## **RESPONSE TO REQUEST FOR INFORMATION - SCEGGS DARLINGHURST SSD-8893**

This letter has been prepared in response to the requests for additional information, dated 12 December 2019 and 13 January 2020, as it relates to the State Significant Development Application (**SSDA**) at SCEGGS Darlinghurst (**SSD-8893**).

Drawing No.
AR.MP.2109

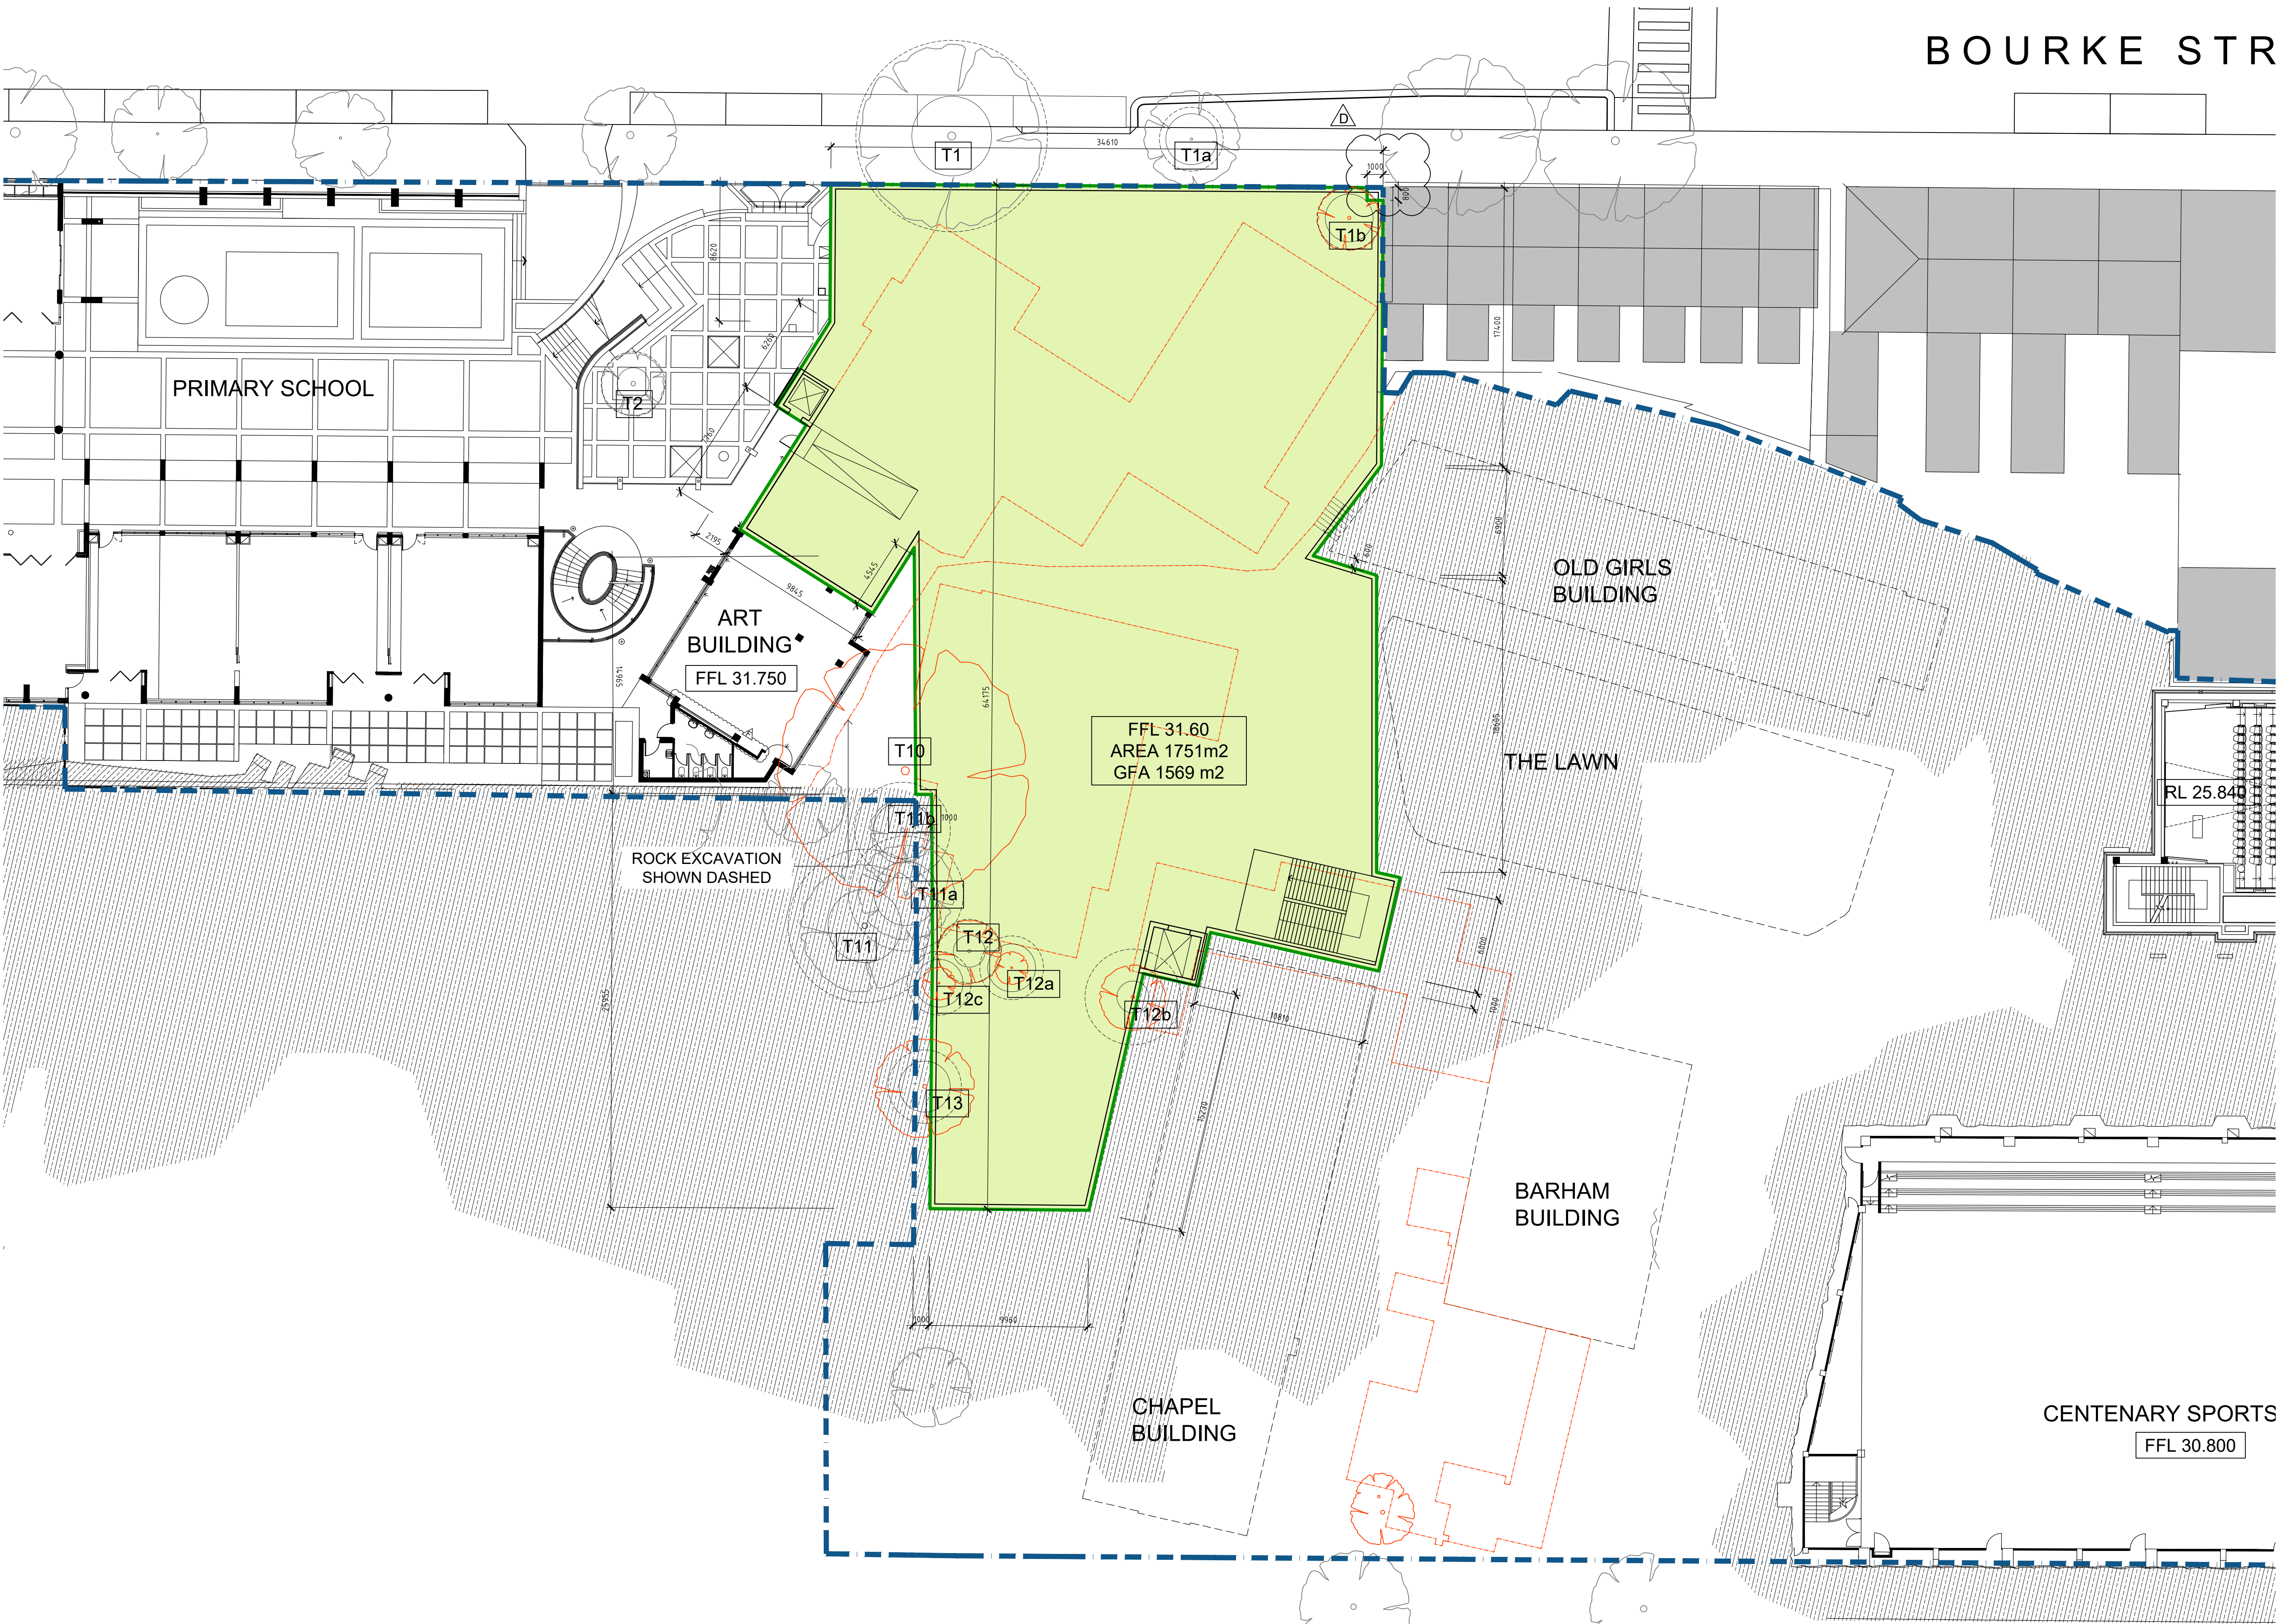
Request	Response
<p><b>Interface with Bourke Street terraces</b></p> <p>The recess shown in the detailed drawings (eg AR.MP.6003) between the heritage terraces and the proposed two storey street wall is not reflected in the proposed building envelope. The envelope should reflect the plans with the depth of the recess to be at least 1 metre from the face of the proposed new building to Bourke Street. The height of this indented recess is to also be amended in the envelope to reflect the detailed architectural drawings.</p>	<p>The envelope drawings for the proposed Multi-purpose building have been amended to include a 1m wide indented recess adjacent to the existing terrace house on Bourke Street.</p> <p>The following drawings have been amended and are attached to this letter at <b>Attachment B</b>:</p> <ul style="list-style-type: none"><li>• AR.MP.1102, Rev D</li><li>• AR.MP.2101, Rev E</li><li>• AR.MP.2102, Rev D</li><li>• AR.MP.2108, Rev D</li><li>• AR.MP.2109, Rev D</li><li>• AR.MP.2110, Rev D</li><li>• AR.MP.2111, Rev D</li><li>• AR.MP.3002, Rev D</li></ul>

- The envelope drawings for the proposed Multi-purpose building have been amended to include a 1m wide indented recess adjacent to the existing terrace house on Bourke Street.

Drawing No.
AR.DA.2105

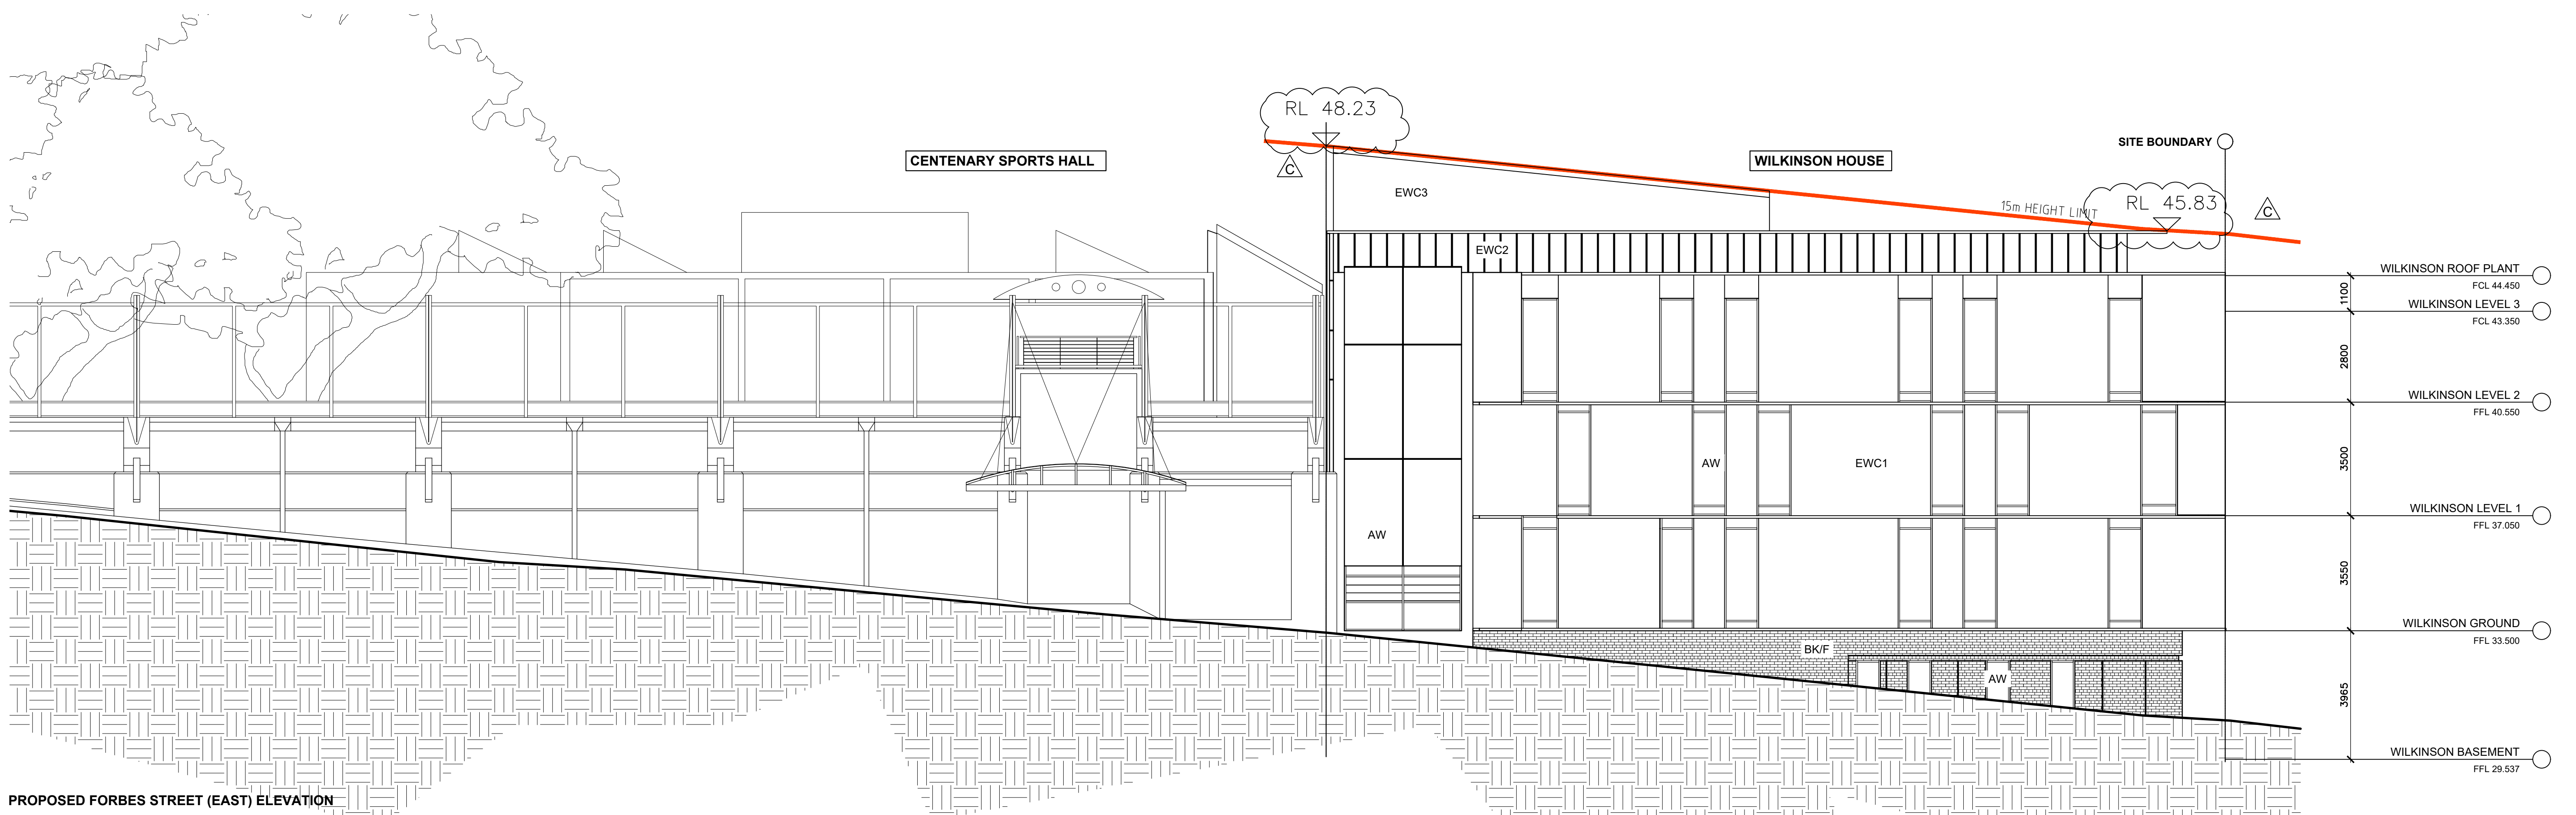
Request	Response
<p>5. Provide justification for not including a green roof on the roof and/or roof plant enclosure of Wilkinson House.</p>	<p>Figure 2 – Wilkinson House Ground Level</p>  <p>The external alcove created by the Wilkinson House recessed stair core is fully visible from within the building by a fully glazed facade, providing natural surveillance and security of this area.</p> <p>The fire egress door has been discreetly located on the side wall of the alcove, which avoids having a blank fire door facing the street and allows for the egress door to not open out over the property boundary (which it is not permitted to do).</p> <p>The alcove will be fully lit at night time so that there are no dark or shaded areas to hide in.</p> <p style="text-align: center;">F O R B E S   S T R E E T</p> <p>Source: TKD Architects</p> <p>A roof plant enclosure has been provided at the roof level and is shown on Architectural Drawing AR.DA.2015. The roof plant takes up approximately half of the roof area. The majority of the remaining roof area has been used to accommodate PV panels meeting the environmental initiatives of the project (Figure 3).</p>

Request	Response
	<p>Given that the roof area is largely occupied by services and plant, the provision of a green roof within the remaining area is not justifiable.</p> <p>The school intend to provide a green roof as part of the Multi-Purpose Building development, which provides a much larger roof area and will be of greater benefit to the school and neighbours.</p> <p>Figure 3 – Wilkinson House Level 3 Roof Level</p>
